CITY OF ALBUQUERQUE

**Planning Department
Transportation Development Services Section**

Re: Certification Submittal for Final Building Certificate of Occupancy for
Rex Lewis Storage Building, [K-21 / D032]
236 Muriel NE
Architect's Stamp Dated 06/24/08

Re: Traffic Circulation Layout (TCL) Submittal for Building Permit Approval for
Offices and Warehouse for Rex Lewis Storage Building [K-21/D-32]
(236 Muriel NE), Albuquerque, NM
Engineer's/Architect's Stamp Dated 09-20-2006

GRADING & DRAINAGE PLAN

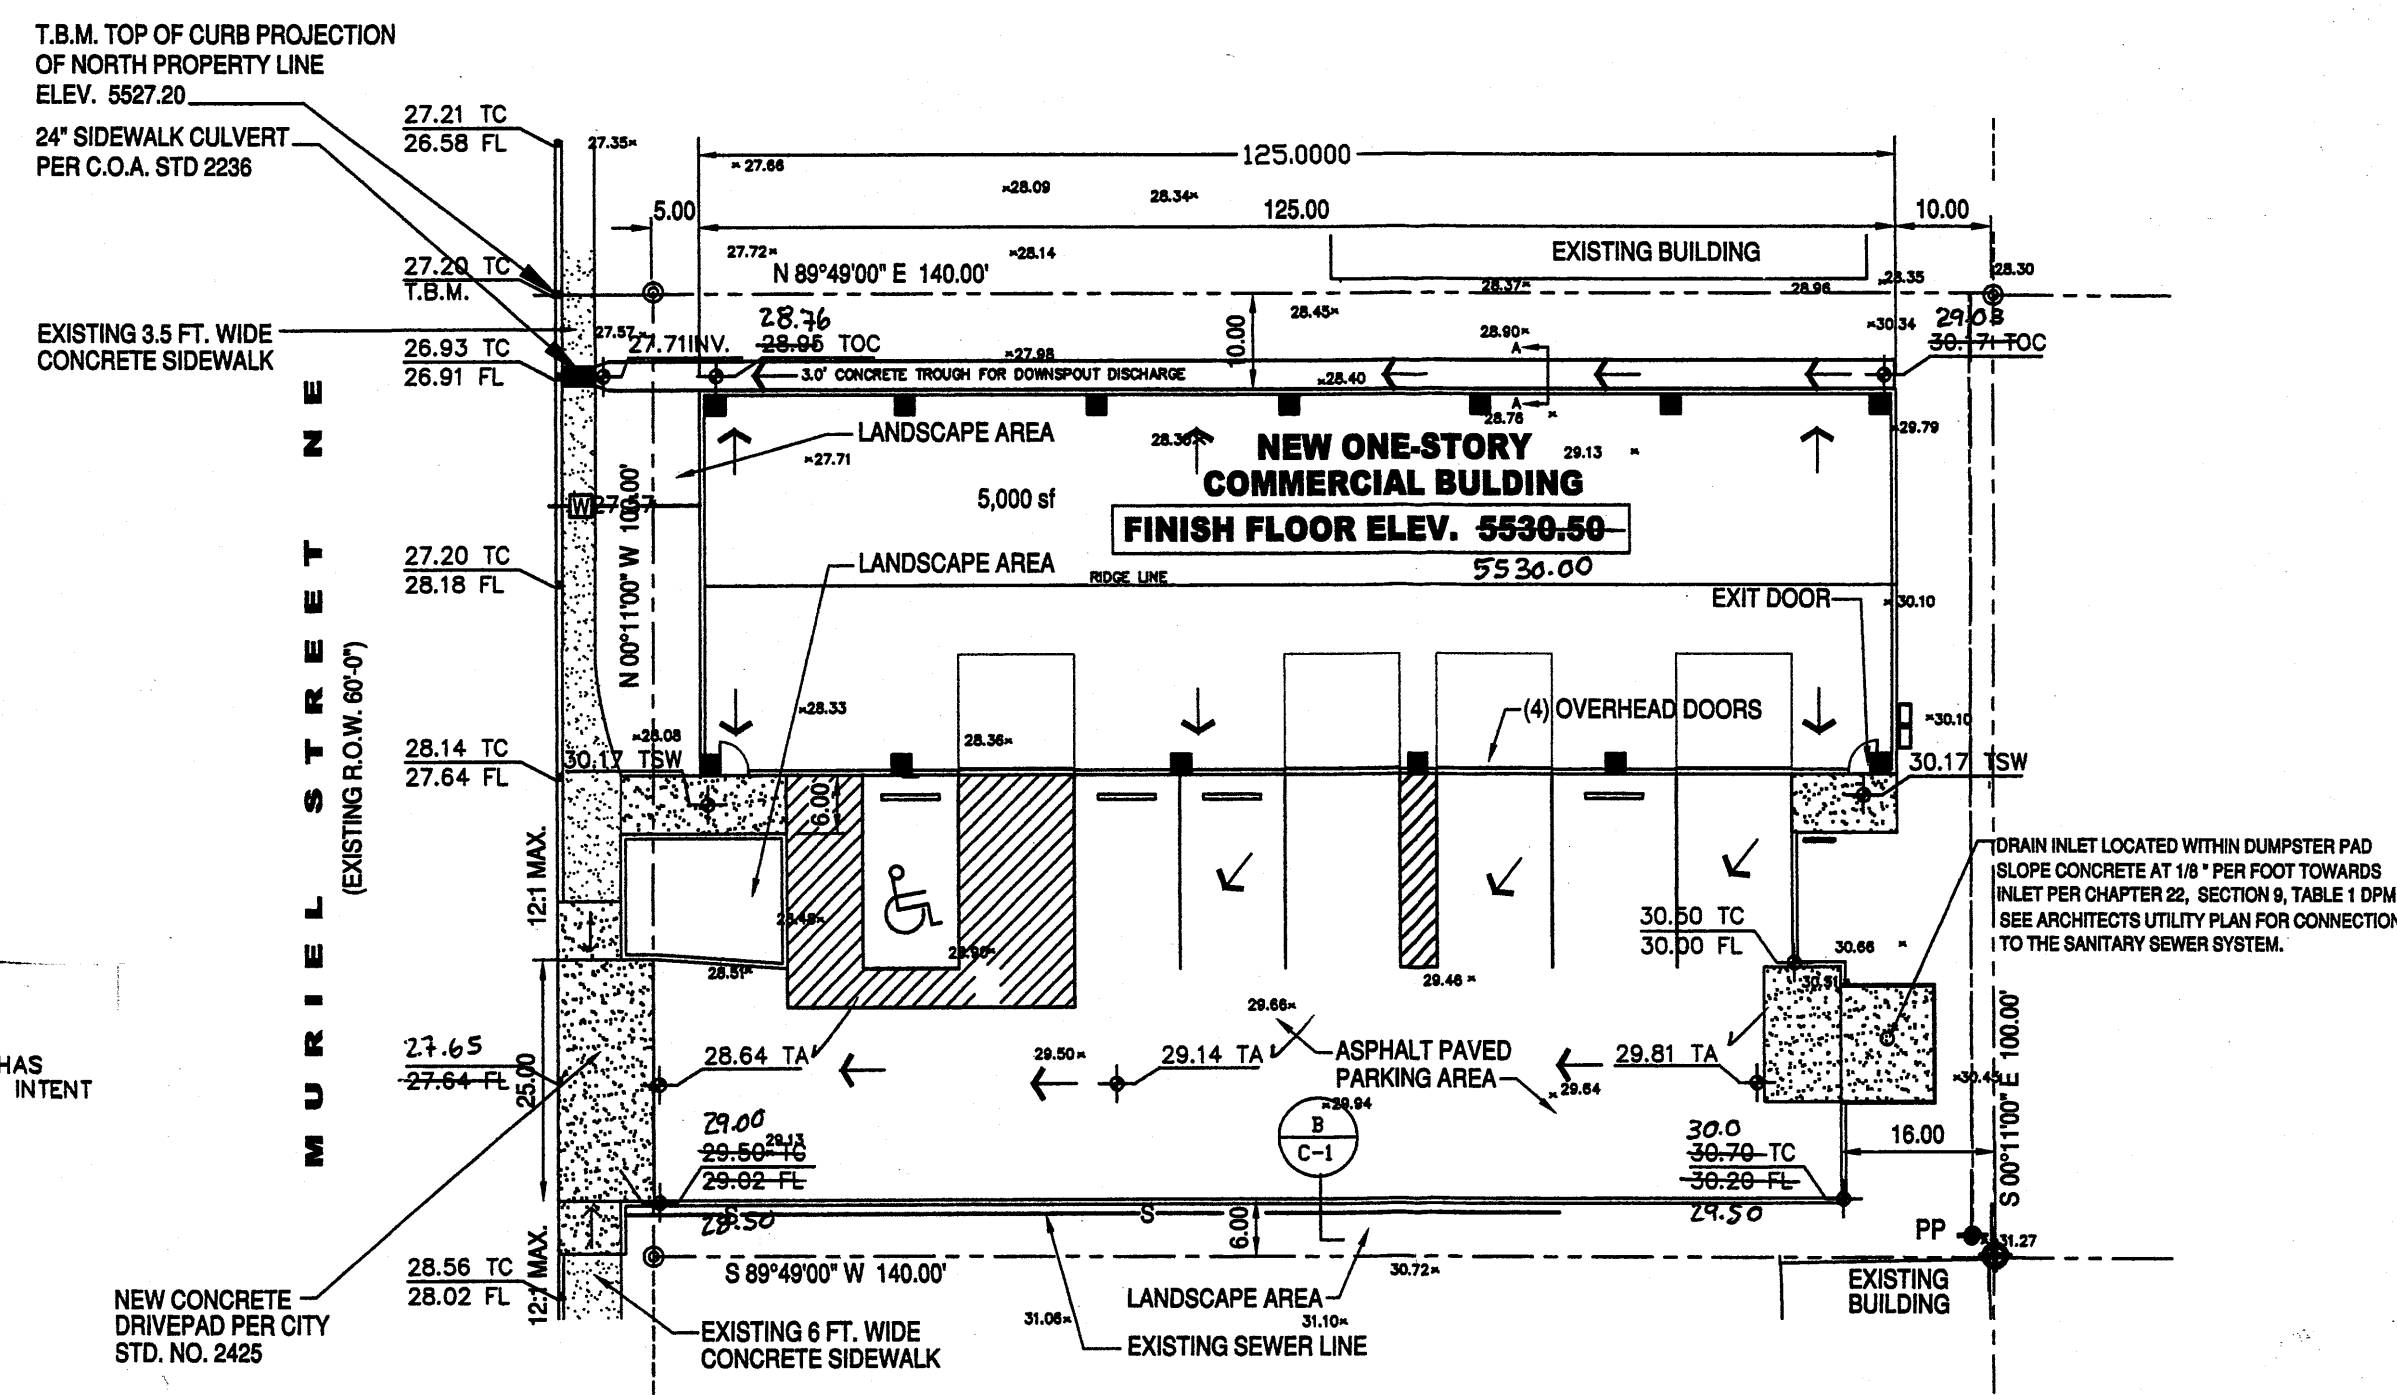
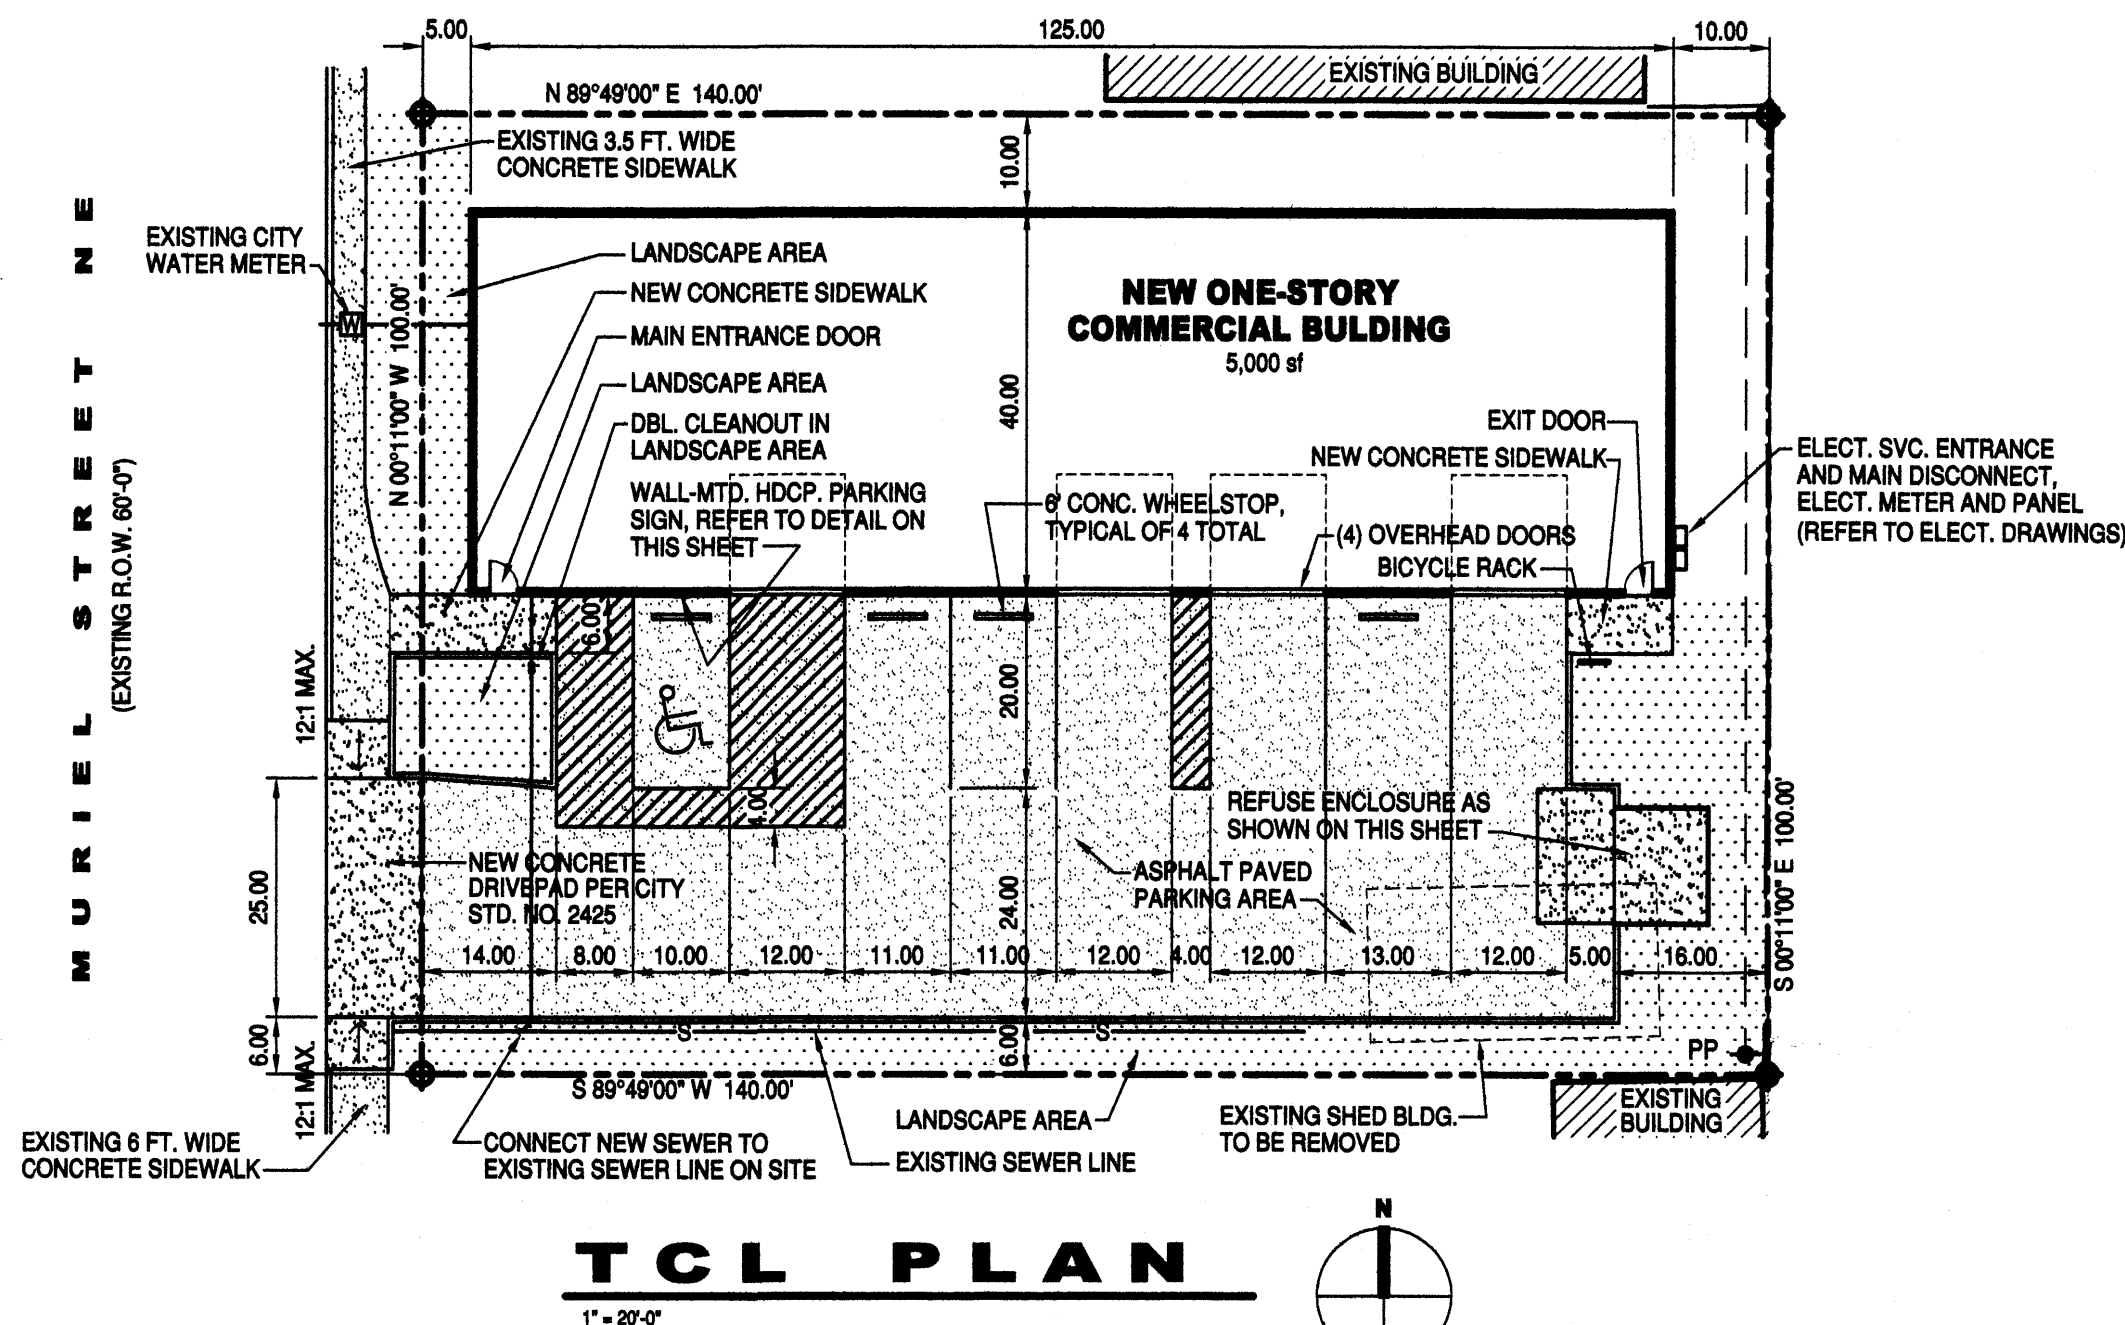
Based upon the information provided in your submittal received 9-26-06, the above referenced plan cannot be approved for Building Permit until the following comments are addressed:

1. Provide a detail of the trash enclosure pad showing the corner elevations and the drain's top of grate elevation.
2. Check your proposed areas; they do not add up to the total site area. Please correct this and amend your flow calculations.
3. Refer to City Standard number 2236, not 2246 for the proposed sidewalk culvert.
4. Update your SO#19 notes, using the sample notes provided.
5. You list an old and new legal description. Are you replatting this lot? If so, you must apply for preliminary plat approval.
6. Please provide a detail for the refuse pad. This detail should shown the elevation at each corner of the pad and the top of grate elevation.

Check proposed areas - treatment B 0.0525 Ac
treatment D 0.2386 Ac

0.2911 Ac \neq Total Area

revise proposed areas
and update discharge calcs

Refer to City Std 2236 for SW culvert

Update 5019 notes

note 3 - revise phone number - 260-1990

Provide a detail for the refuse pad

- detail should show four corner elevations
and top of grate elevation
